Infrastructure Officer
Planning Services
Lincolnshire County Council
County Offices
Newland
Lincoln LN1 1YL

Application by One Earth Solar Farm Limited for an Order granting Development Consent for the One Earth Solar Farm.

Deadline 2 submissions from Lincolnshire County Council including responses to ExQ1 and comments on deadline 1 submissions.

Figure 2.1 Waterbodies within the Order Limits and the 250 m buffer

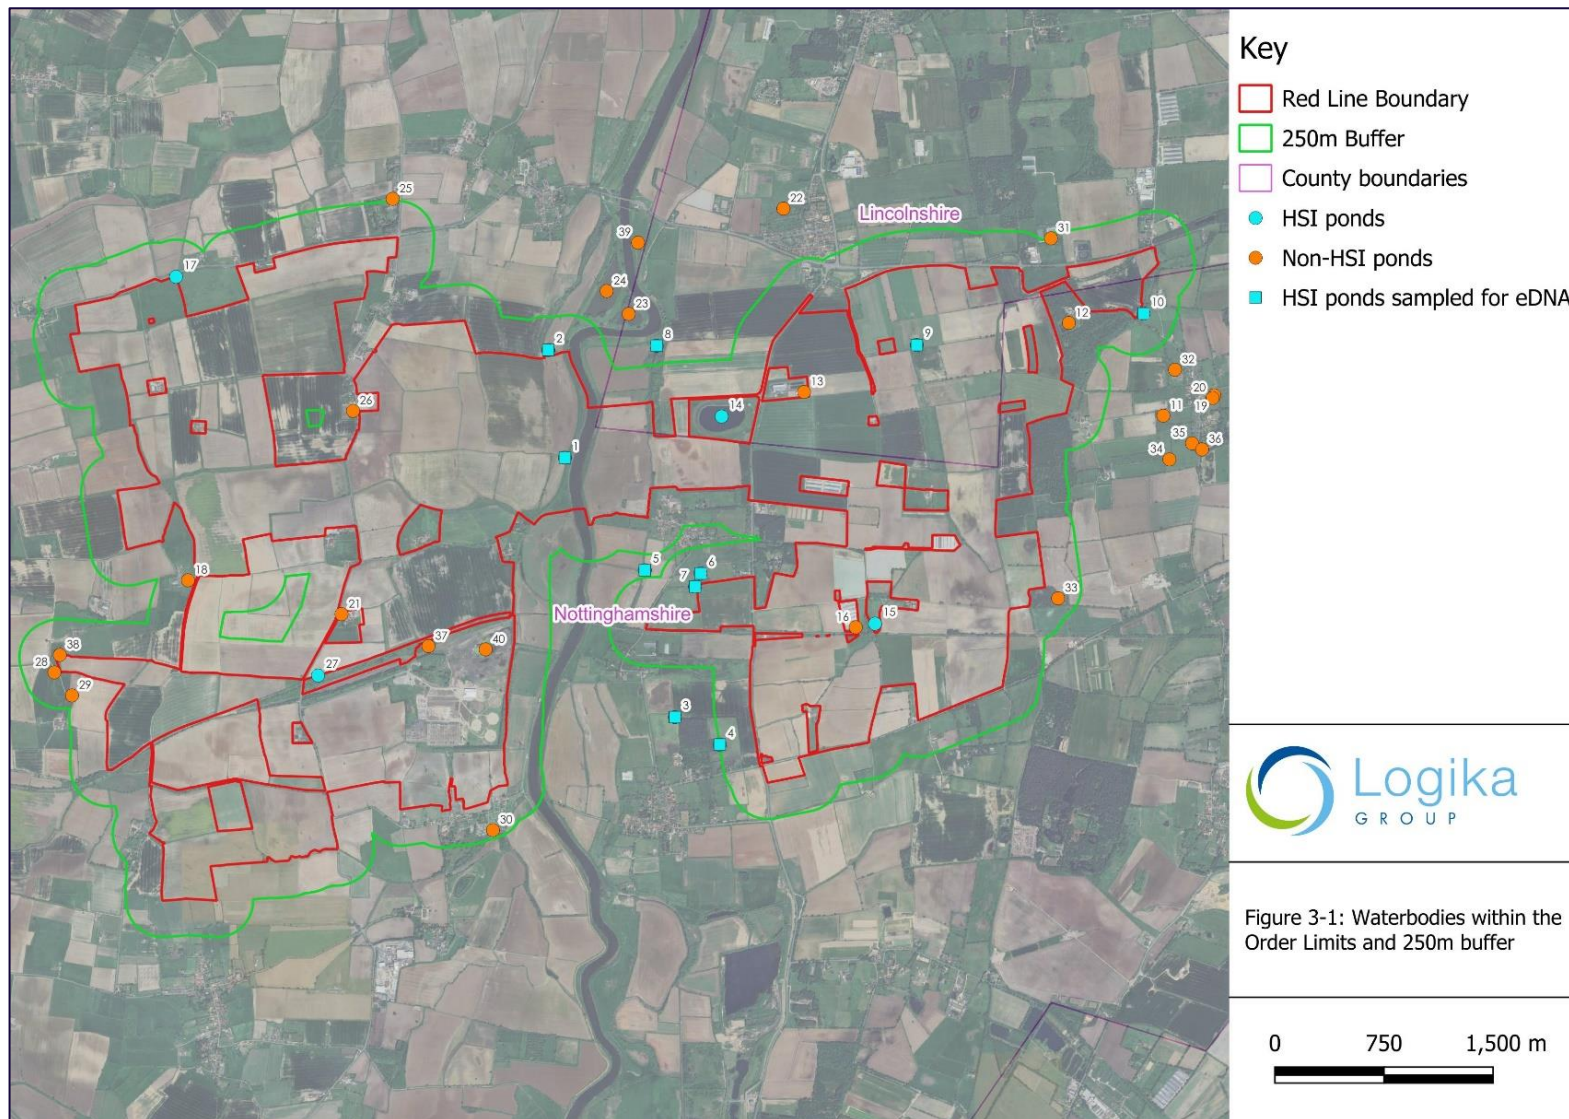
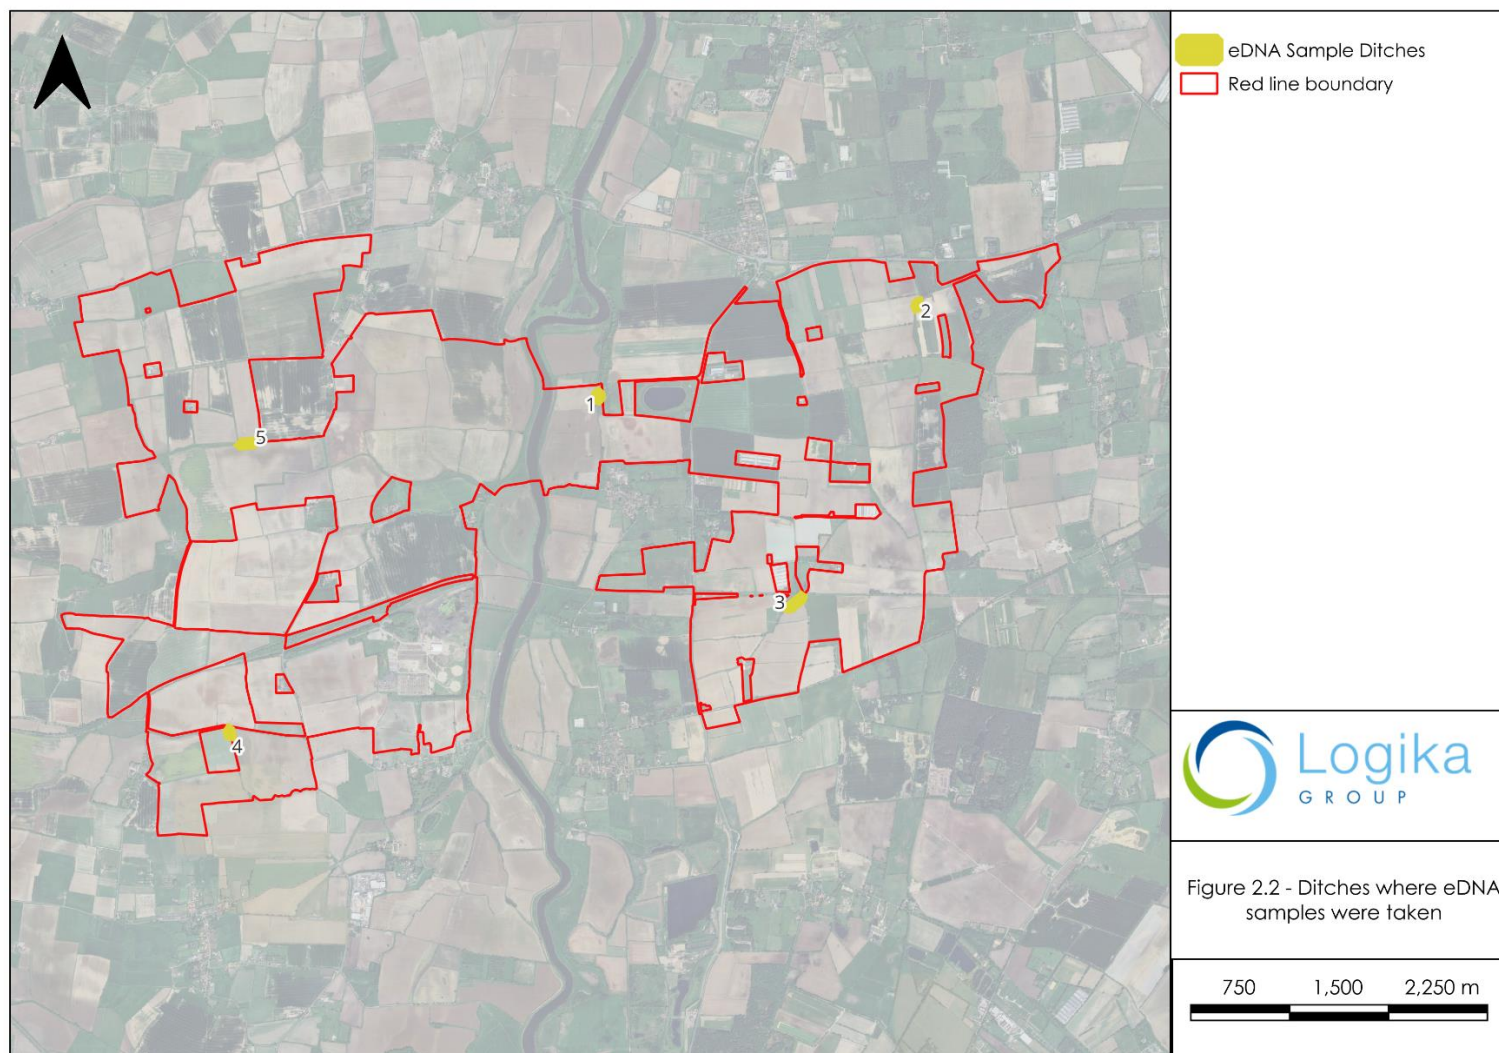
- Great crested newts: LCC notes that additional eDNA surveys for great crested newts have been carried out in 2025 and that all results were negative. However, LCC notes that several ponds both within the DCO area and in the vicinity have not been surveyed due to access constraints. The results of the desk-based assessment suggest that there remains potential for undetected populations of great crested newts in the area. Table 6.6, C15 confirms that the Ecological Clerk of Works will be responsible for undertaking checks for protected species prior to vegetation clearance and that European Protected Species are found works will need to stop until a license is obtained from Natural England.

As stated above LCC is of the opinion that there remains potential for great crested newts to be present due to lack of survey coverage of some ponds within and adjacent to the DCO area.
